Our Ref: R/2017/11/G
File No: 2019/546372

**Request for Advice – ATP Locomotive Workshop (Bays 5-15) – SSD 8449 MOD 4 – 2
Locomotive Street, Eveleigh 2015**

Thank you for your correspondence dated 21 October 2019, inviting the City of Sydney Council (The City) to comment on the modification application. The proposal involves internal alterations to the design and layout of commercial tenancies on the ground floor and Level 1 of Bays 5-13 of the Locomotive Workshop. Specifically, the works include new access bridges on Level 1, addition of a sliding door, changes to the number and configuration of staircases and lifts, increase in the size of the atrium of Bay 12 South, provision of a minor new plant room and movement of an intertenancy wall.

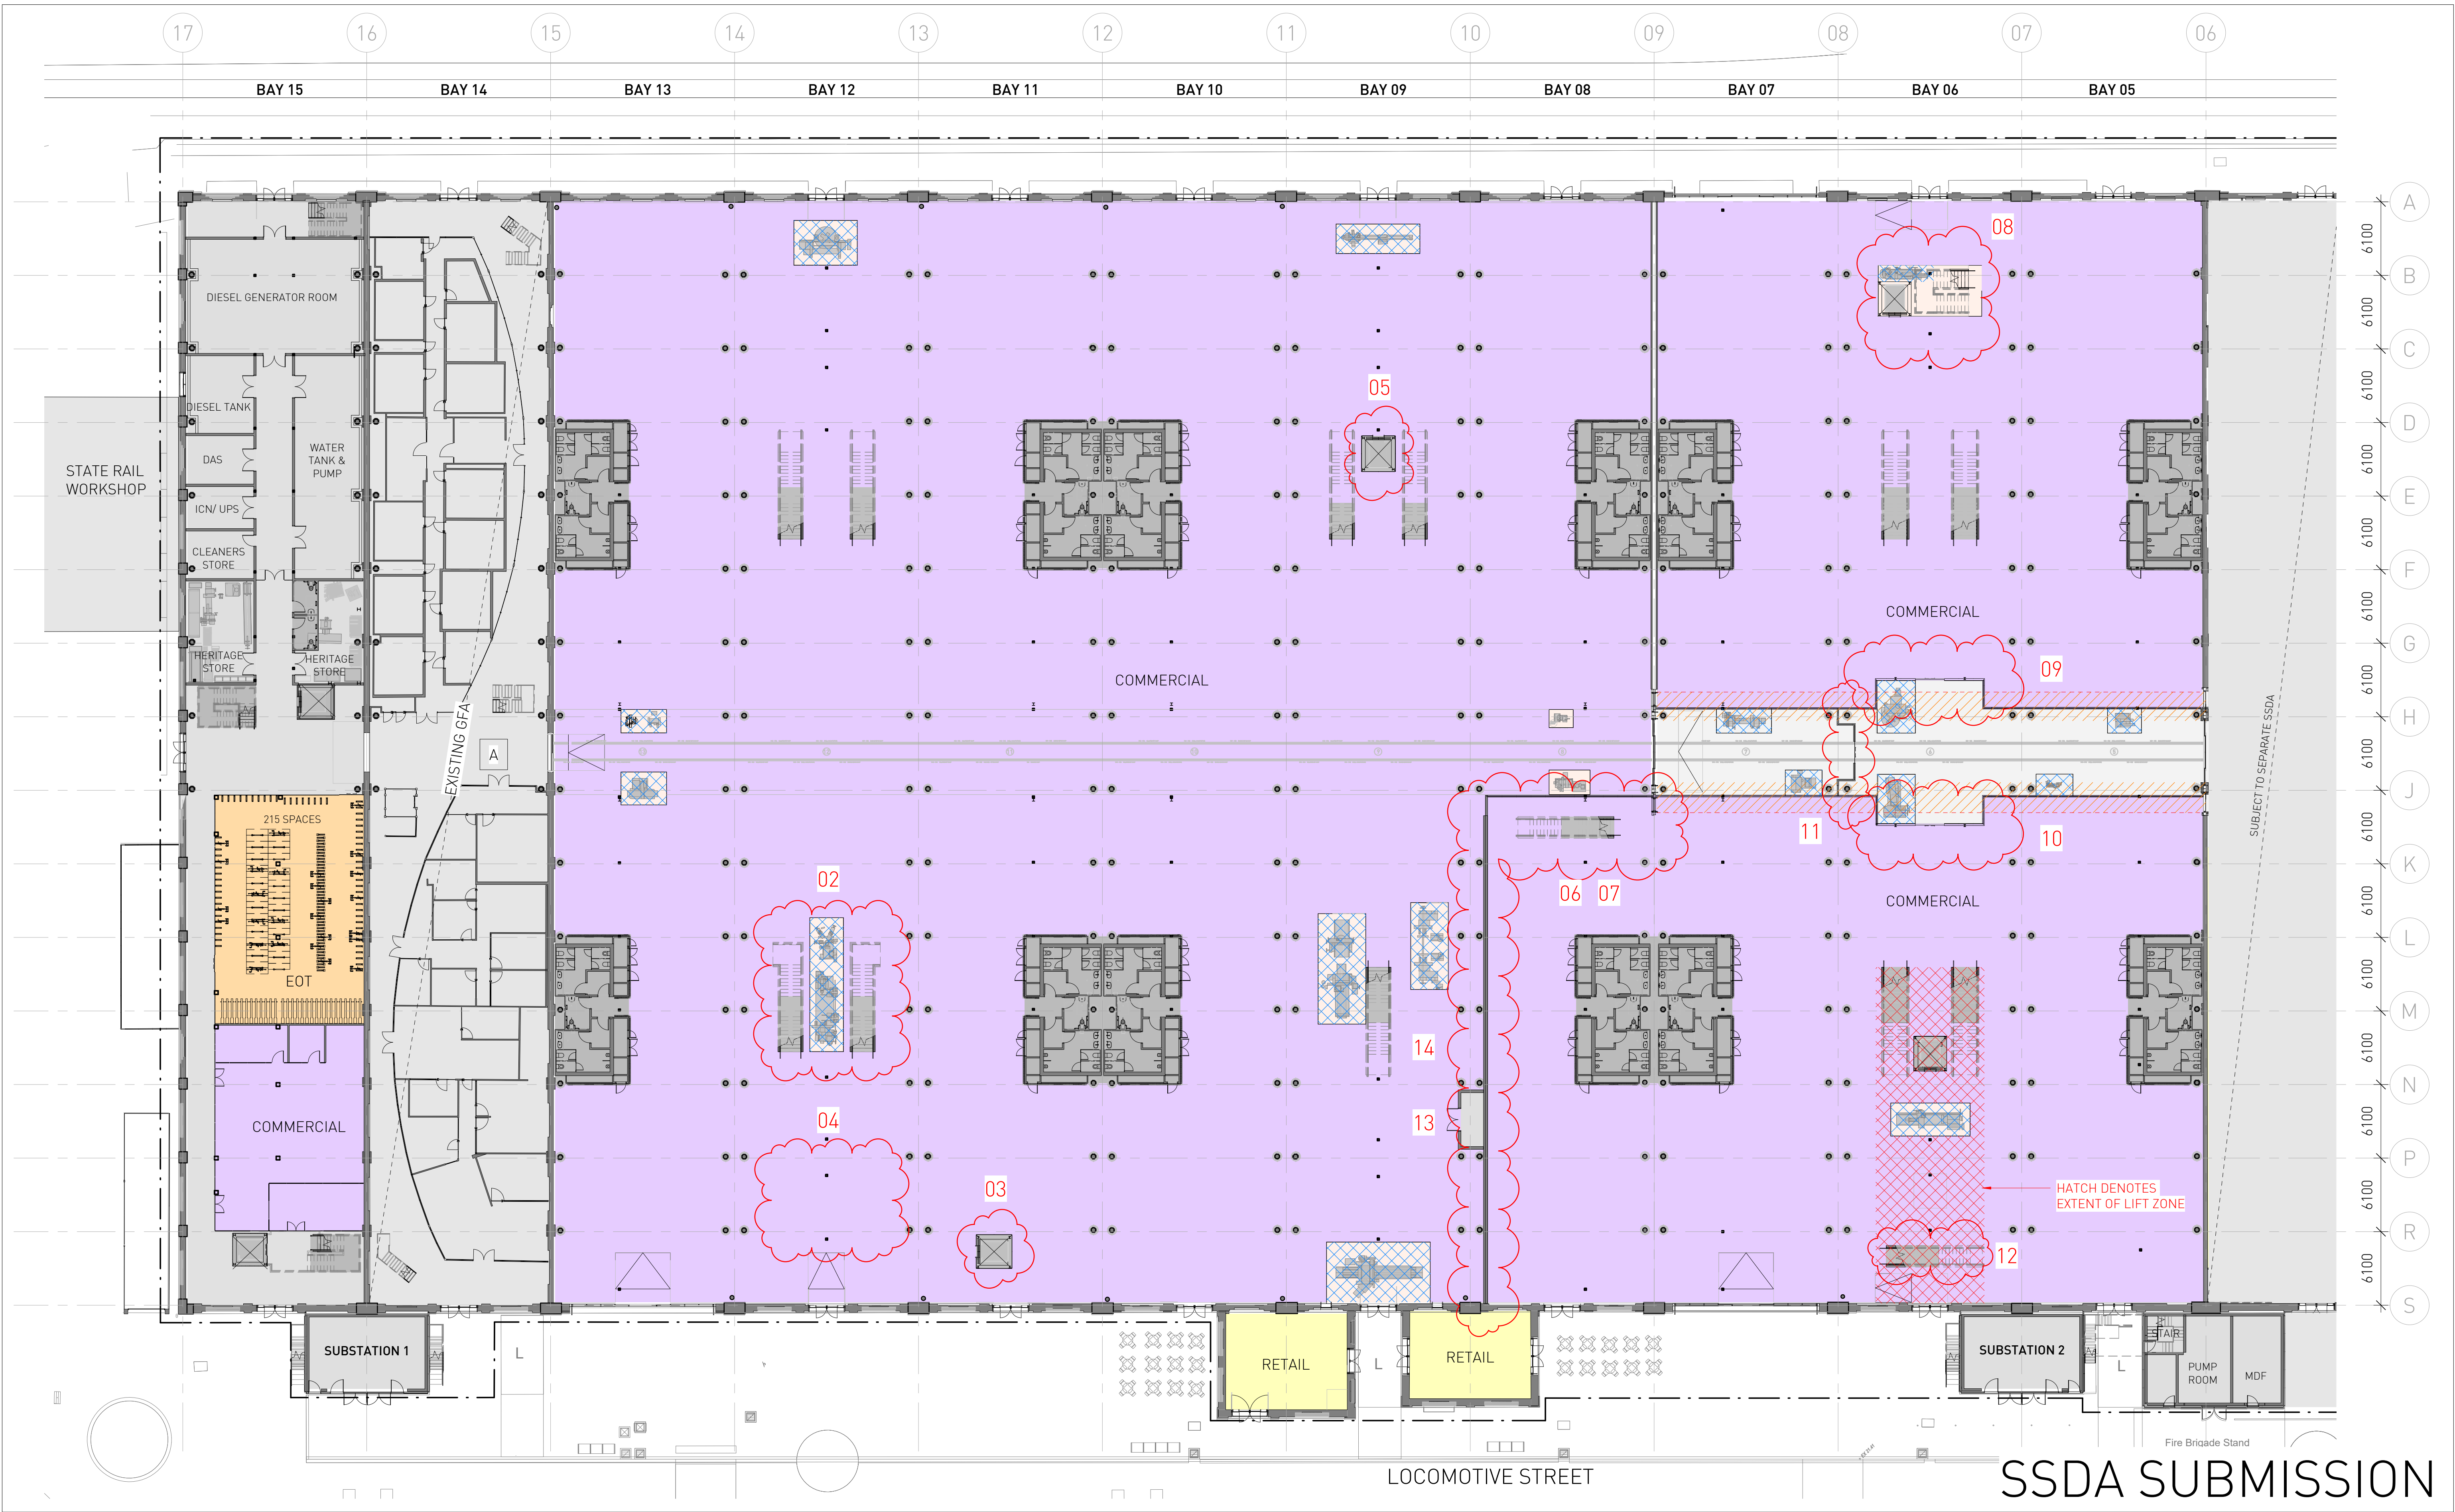
1. Proposed Modification No. 11, as outlined in the Modification Report prepared by Ethos Urban, relates to the addition of a sliding door. It located within the approved view zone, which is intended to be kept open and provide a clear sightline through the building. Architectural drawings have not been submitted to determine the door specifications, structure and materials used to ascertain that the proposed modification does not obstruct the continuity of views through the view corridor.

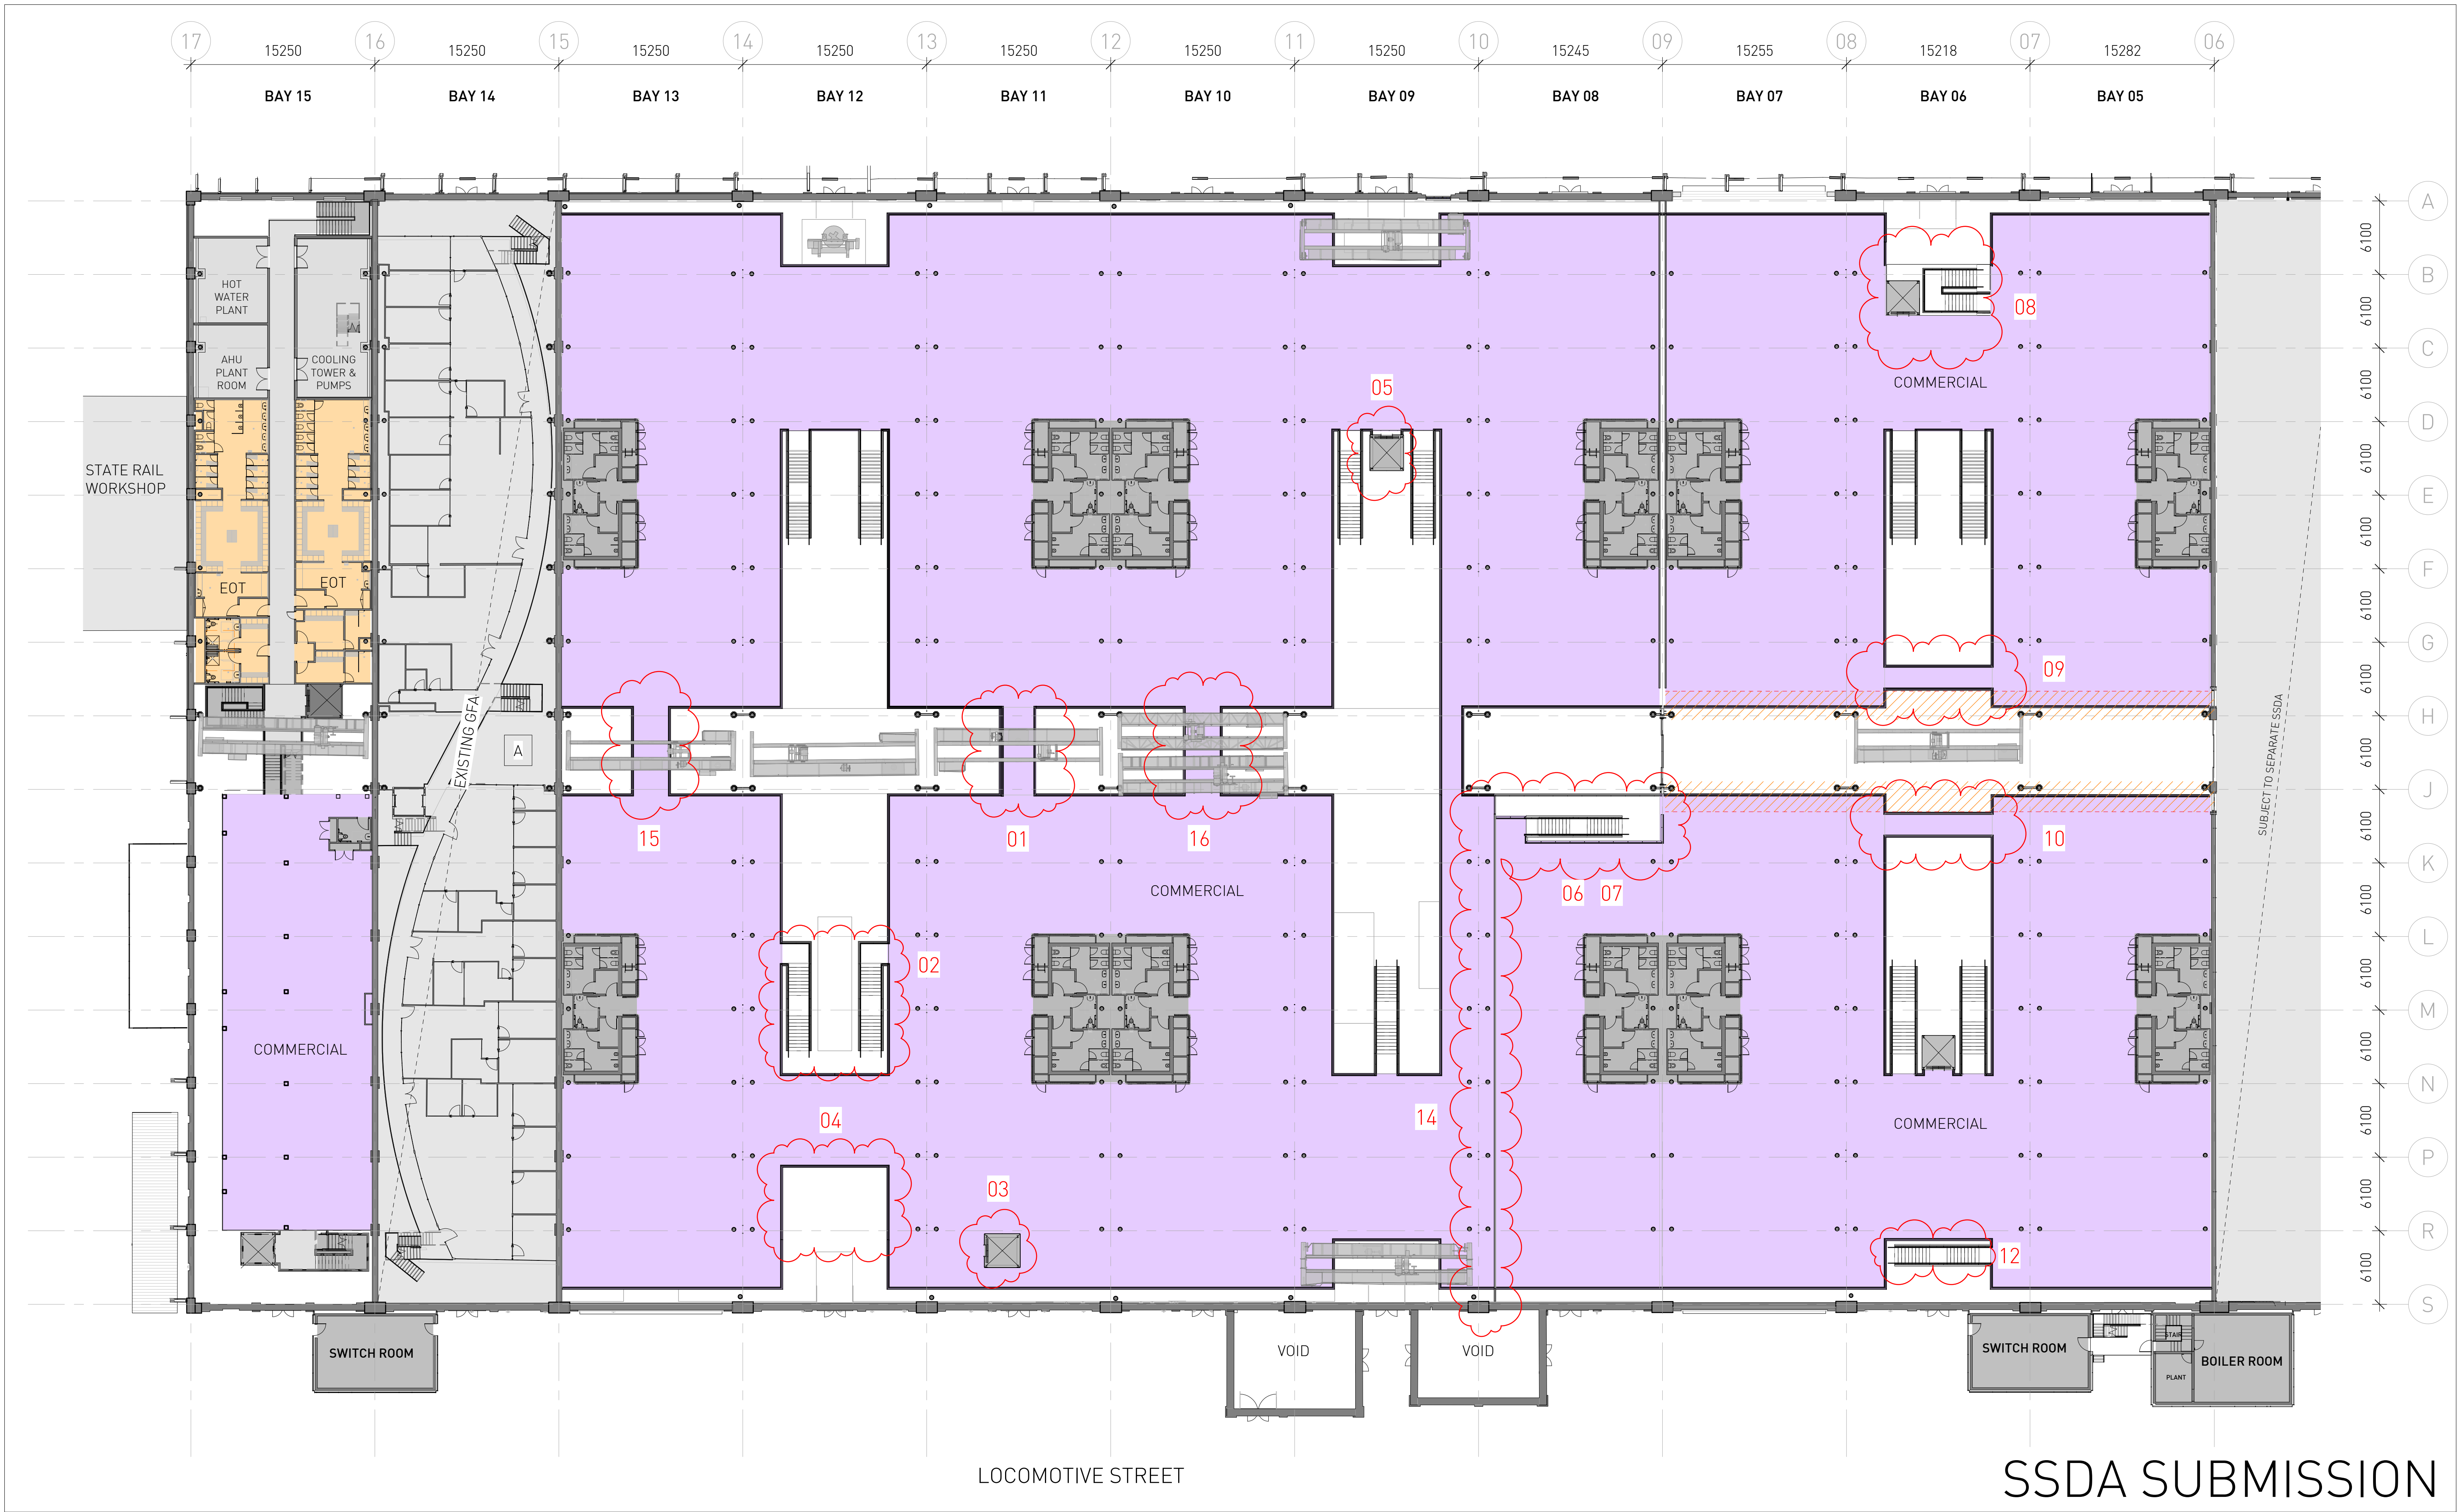
2. The Modification Report outlines that Proposed Modification No. 16 relates to the reconfiguration of the link bridge at Bay 10 Central and it is to be widened and centred to improve connectivity and internal circulation. The Heritage Impact Statement and architectural drawings indicate that an additional link bridge is to be provided. Overall, the discrepancies in the documentation does not allow the City to understand the proposed scope of works within Bay 10 Central.
